**From:** [Kim Person](#)  
**To:** [Jeff Watson](#)  
**Cc:** [mike Ross](#); [dalyville@comcast.net](mailto:dalyville@comcast.net); [Jim Muhlbeier](#)  
**Subject:** (squared up SP-10-00015)  
**Date:** Sunday, January 23, 2011 10:49:51 PM

I was notified by your office of the short plat application (file number Squared up SP-10-00015).

SQUARED UP SHORT PLAT
 A PTN. OF THE SW 1/4 OF THE SW 1/4 OF SEC. 24, T.20N., R.15E., W.M.
 KITTITAS COUNTY, WASHINGTON

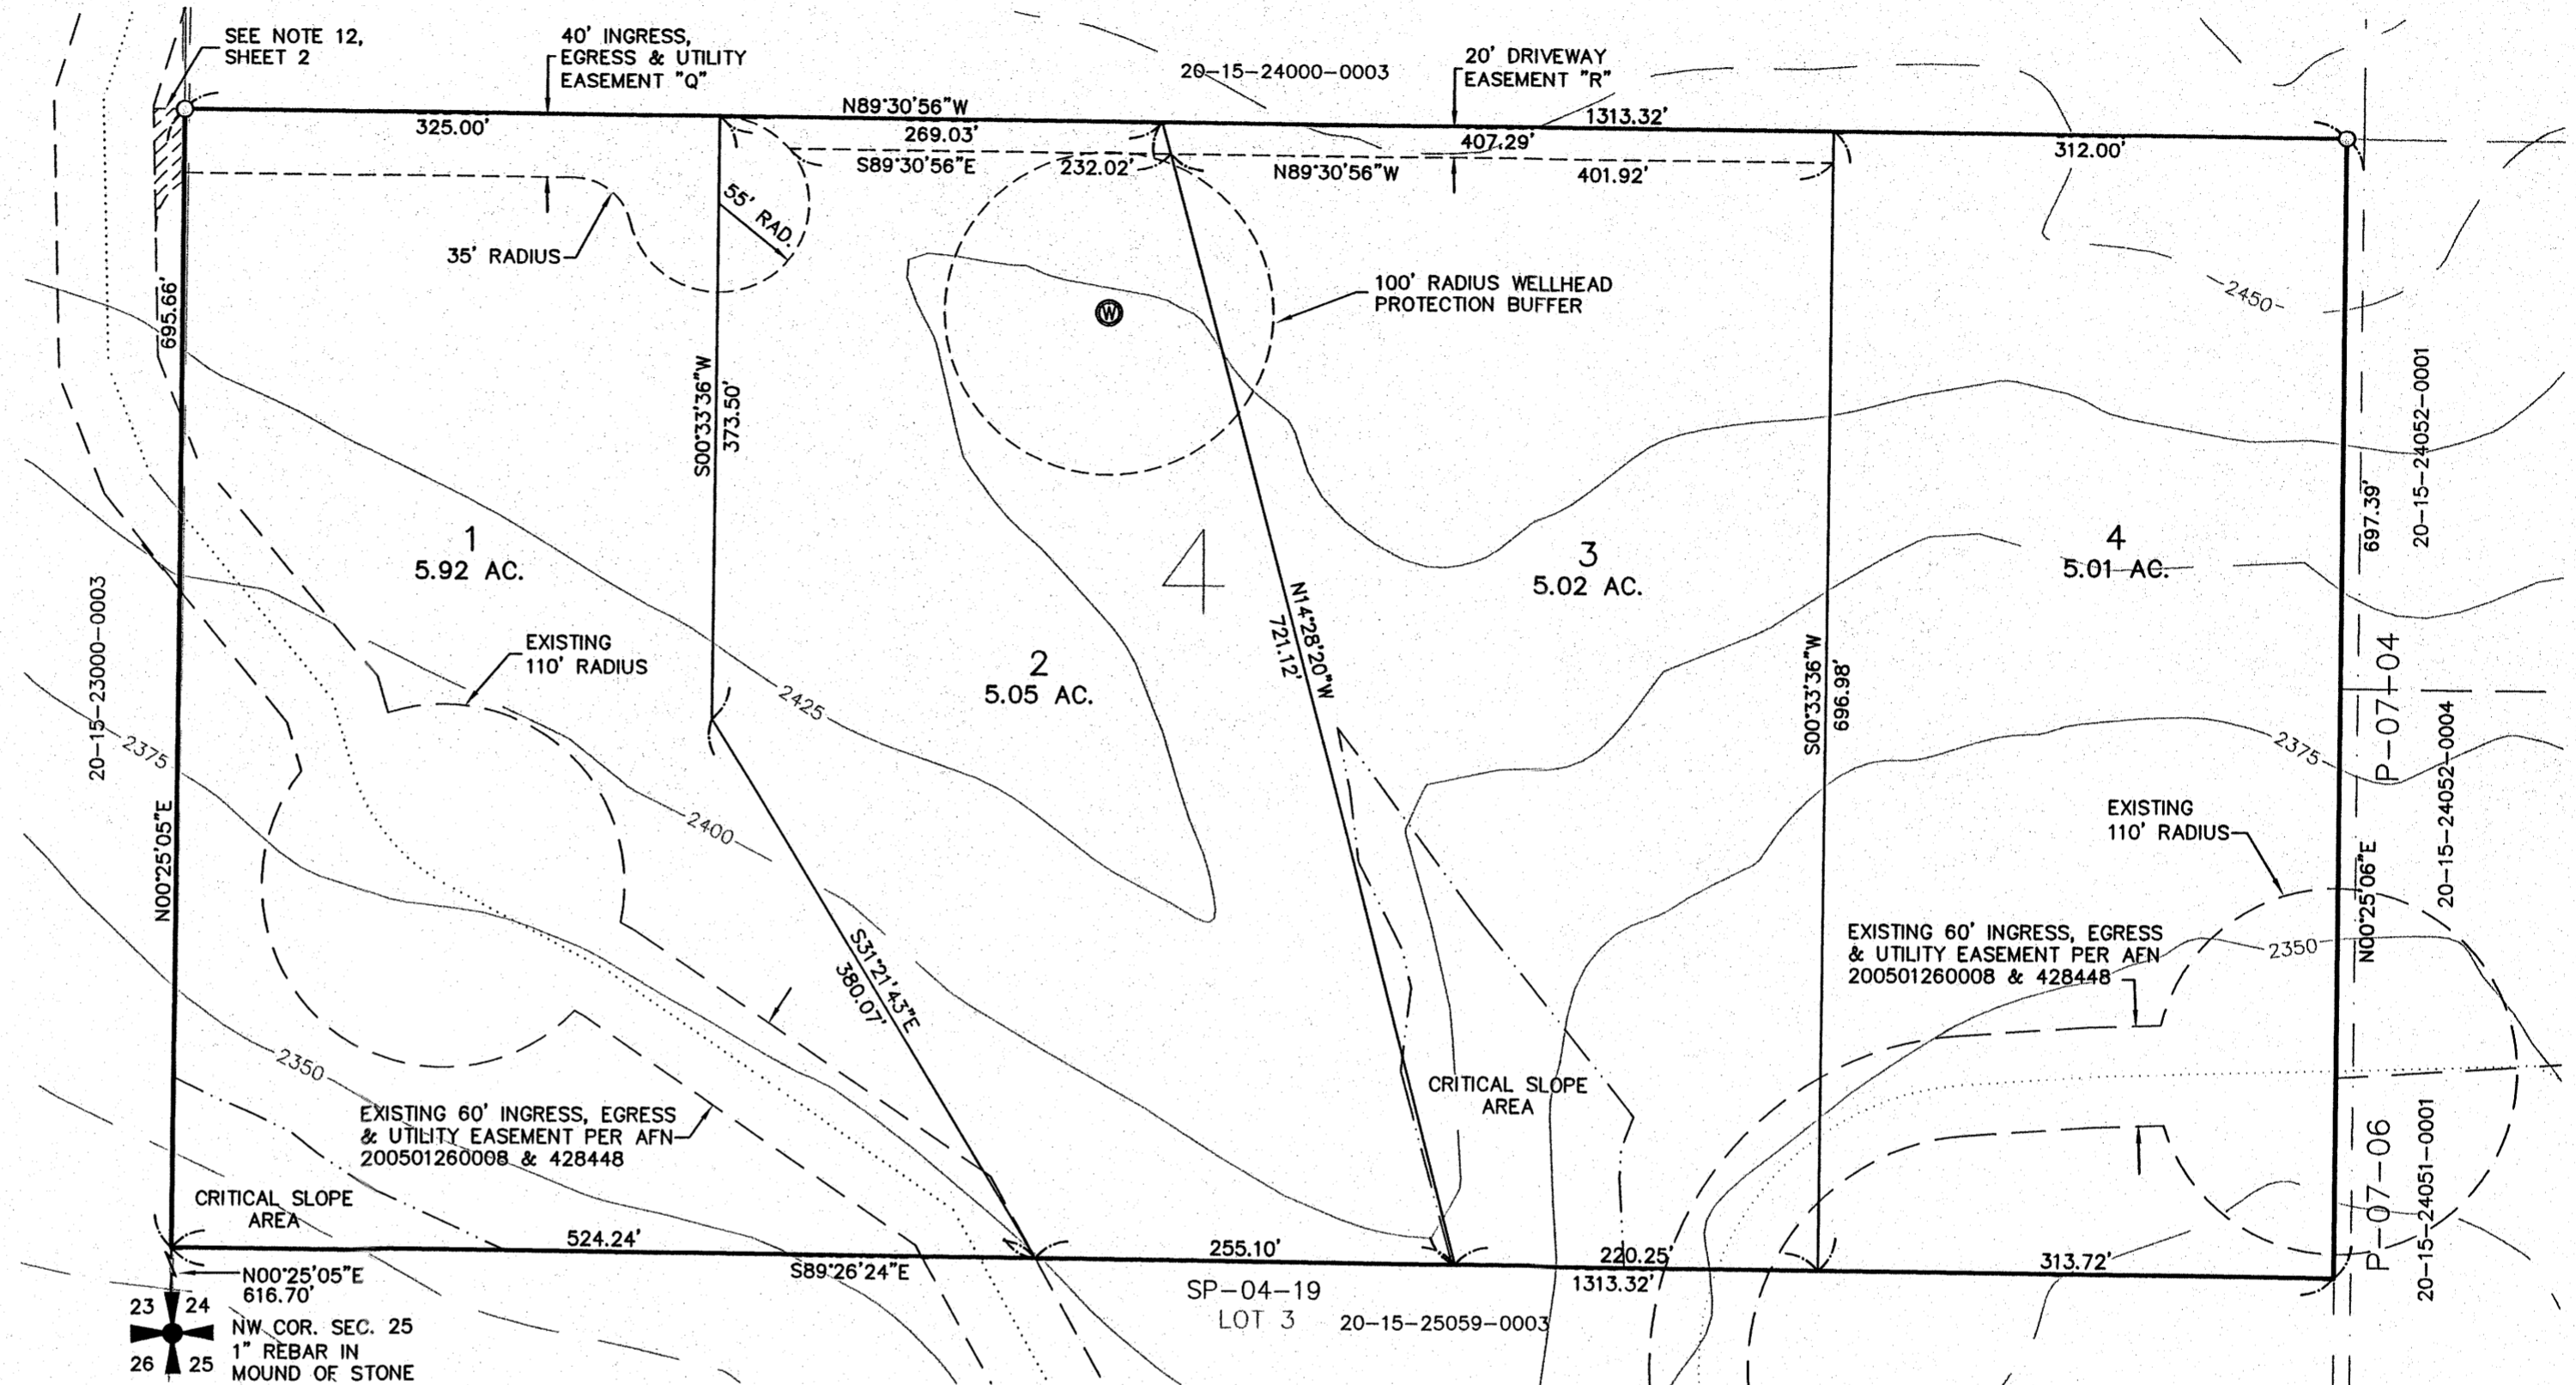
1. Water, How with the current moratorium could it even be considered by the county to approve more building sites. The majority of wells in this area produce from 1 1/2 gal to 2 1/2 gal a minute and are 700' deep. This alone makes no sense to add a larger burden on the water available. I have first hand experience with water availability, drilling a 750' well and then having to buy a water right so that I can use my well.

2. Development monitoring, monitoring of development in the county in the past in this area has caused damage to down hill land owners property. Erosion is already a problem in this area, due to the last supposedly upgrade to the road.

3. The easement road that is noted as secondary access is a problem area for a road as it has surface water issues and if improved It would not be a secondary access it would become a primary access just because the roads in Sec 23 have been improved and are much easier to navigate.
